Gatwick Northern Runway

TR020005

National Highways Responses to the Rule 17 Letter issued on 20 August 2024

August 2024

Appendix A: Gatwick NRP Temporary Compounds and Construction Vehicle (HGV) Access Routes

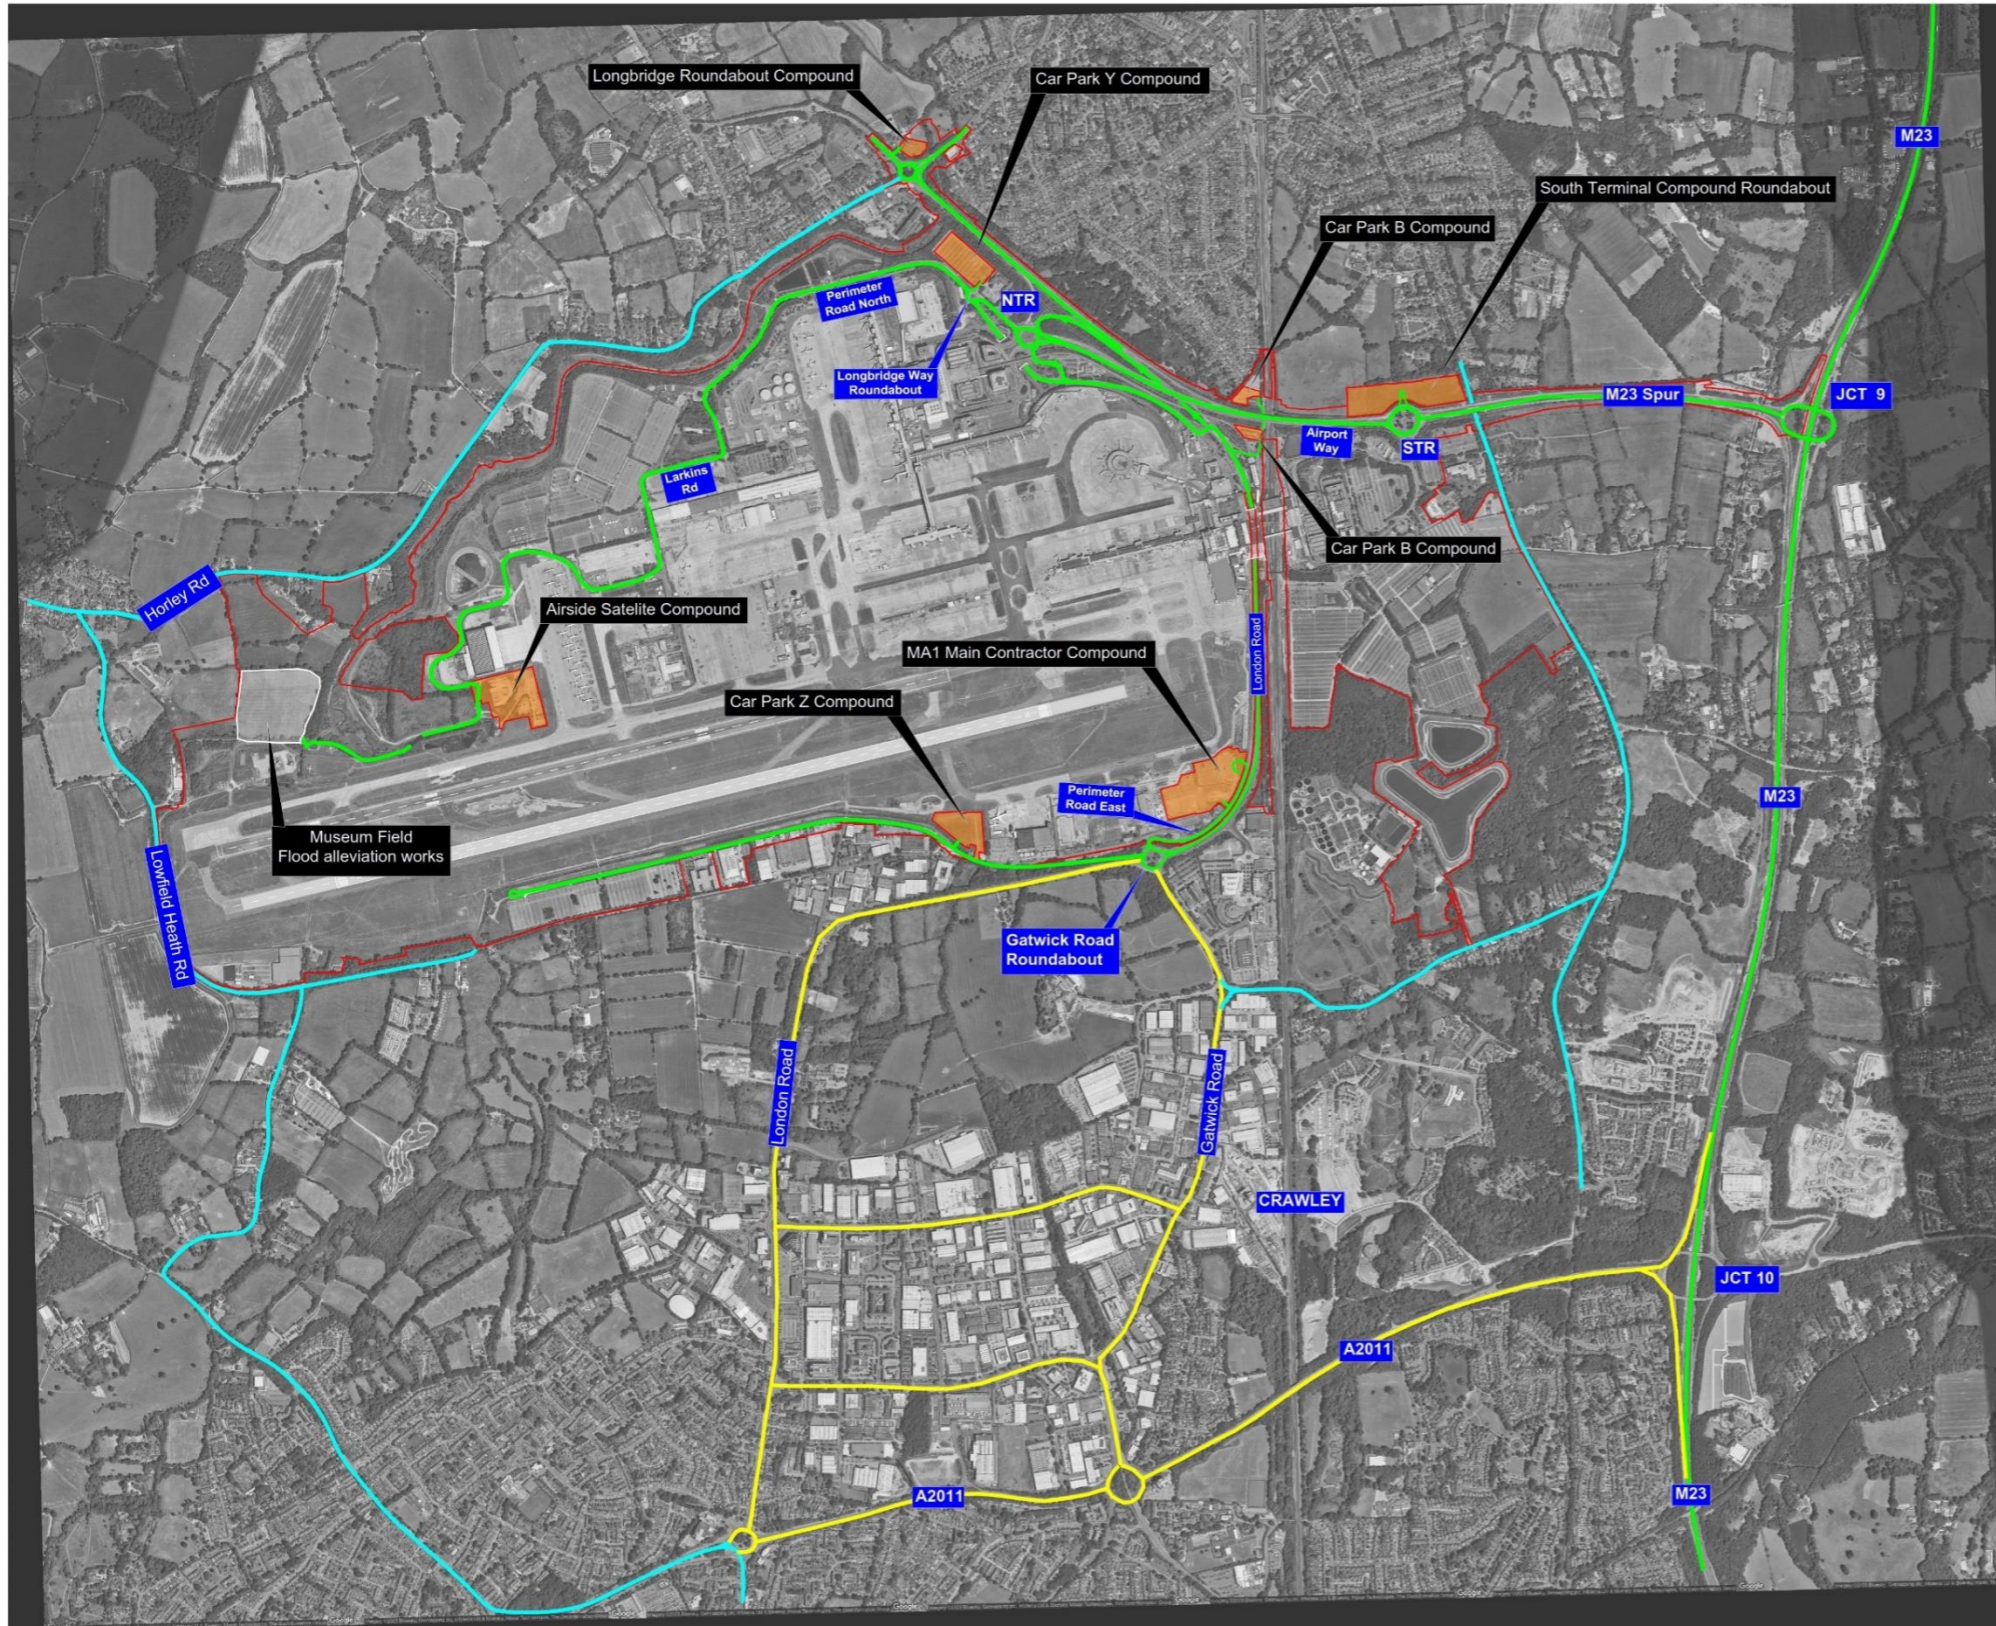
Q No	Question to / Response by	Question Posed	National Highways Response Provided
R17f.5	National Highways	<p>South Terminal Roundabout Contractor Compound Access</p> <p>In their submission [AS-165], Surrey County Council state that <i>'We are of the view it is therefore unlikely that NH will give consent for access to be taken from STR and, therefore, there will be no ability for the land at Bayhorne Farm to be used as a construction compound'</i>.</p> <p>Please confirm whether National Highways is in a position to confirm whether consent is likely</p>	<p>National Highways has confirmed in its Covering Letter to Deadline 10 that the Applicant has provided the additional information requested at Deadline 9. After reviewing this information, National Highways is content with the justification set out and confirms that this matter is now agreed. National Highways agreement to the temporary access is conditional on the commitment by GAL that this access will be removed following the construction period.</p>
